From: Iles, Peter <Peter.Iles@lancashire.gov.uk>
Sent: 17 August 2022 08:44
To: Adrian Dowd <Adrian.Dowd@ribblevalley.gov.uk>
Subject: Lower Abbott House, Osbaldeston

Further to our meeting and my earlier email, I wanted to confirm that from the information that we have at present, I see no real benefit in heritage terms of retaining the extant façade to Lower Abbott House, or to rebuilding a facsimile of the façade, and rebuilding the rear in a more modern style. The style of the extant (altered) façade is not either particularly typical of the locality or so unusual as to stand out within the settlement. Of course this would need reconsideration if it could be shown that early architectural elements do survive and could be retained.

name  
proposed elevations

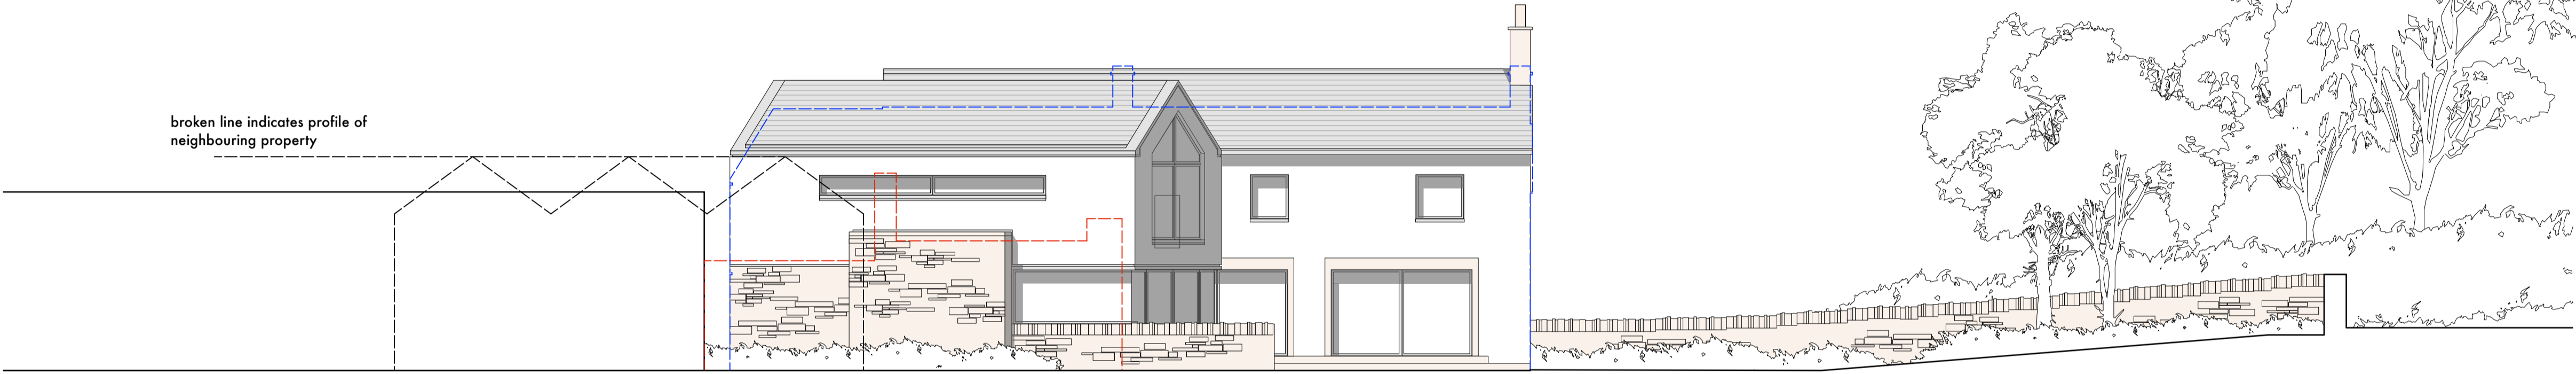
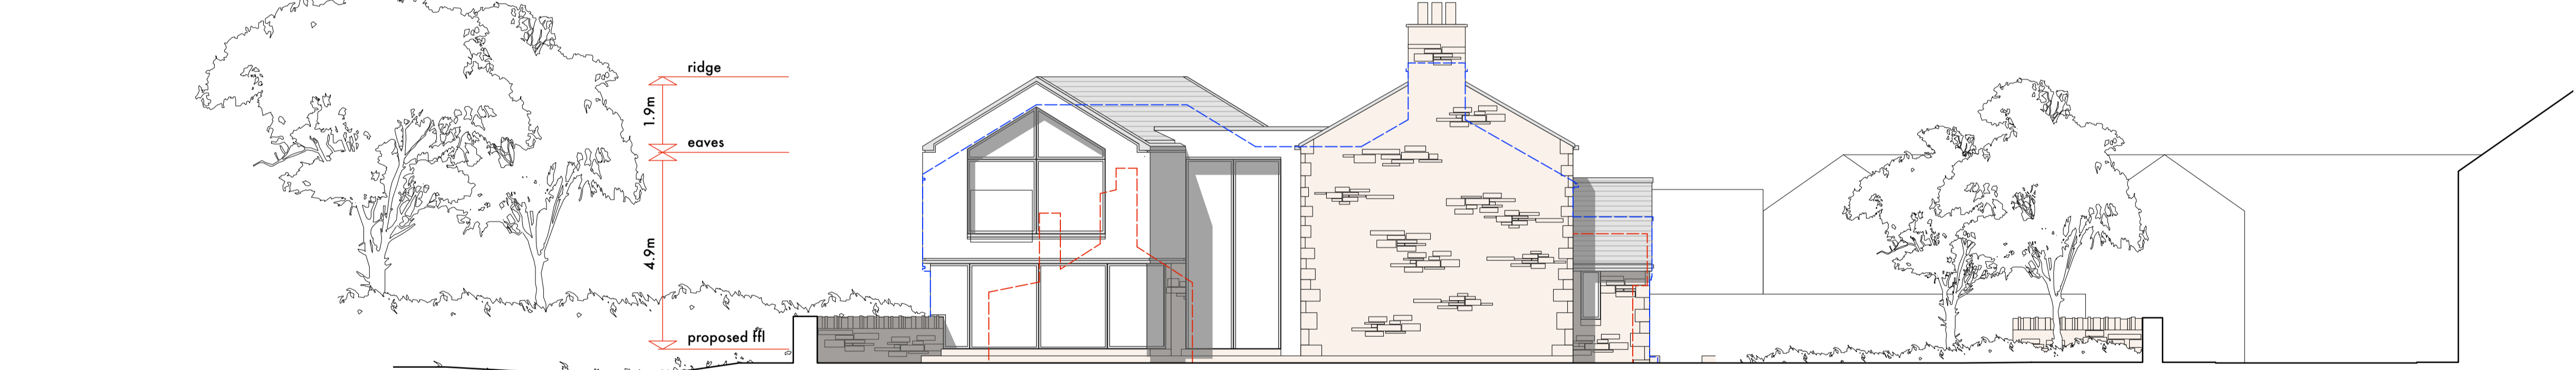
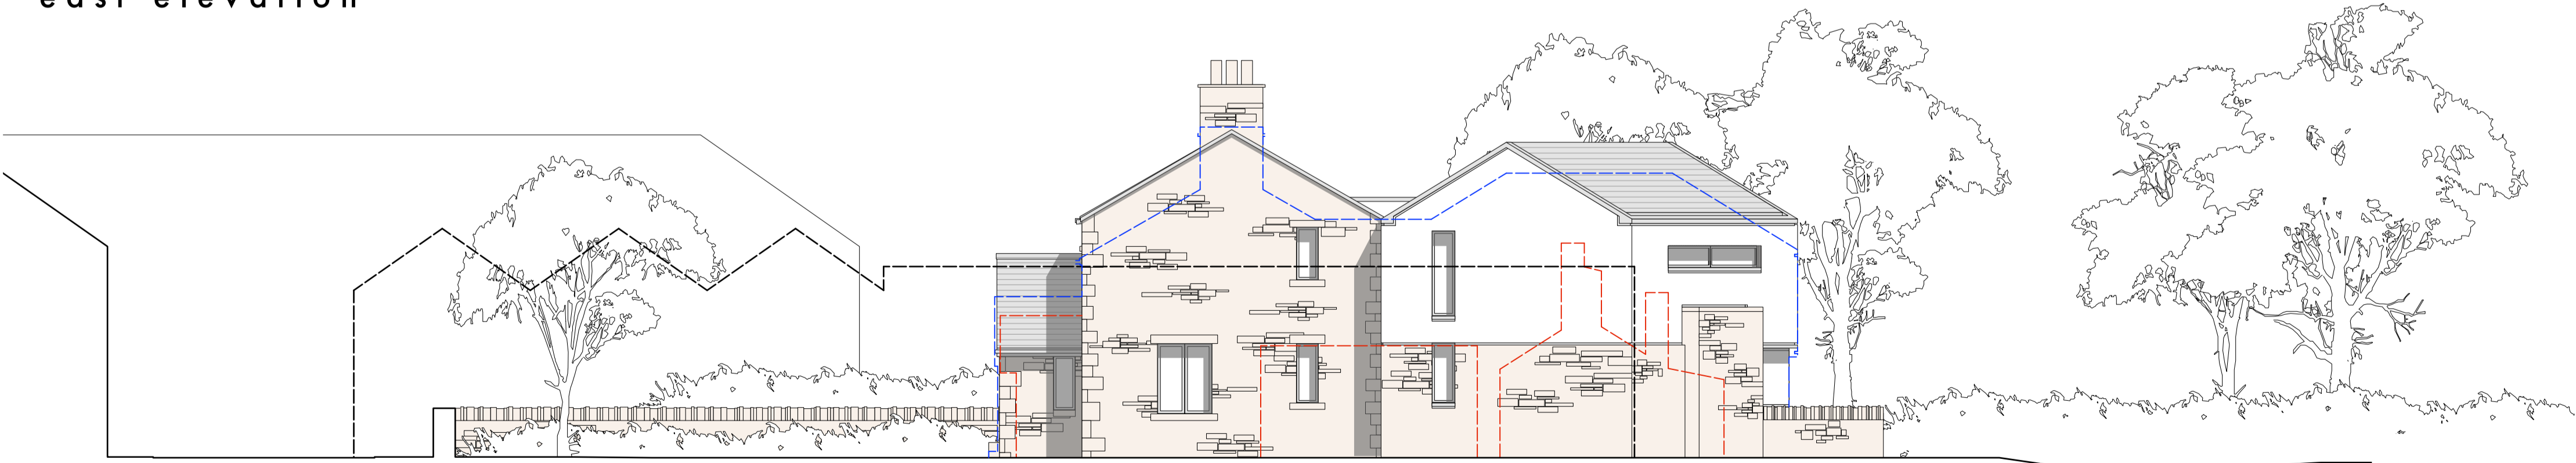
Instead I would probably recommend that a new, quality, modern building be designed and built, using an appropriate palette of locally-traditional materials.
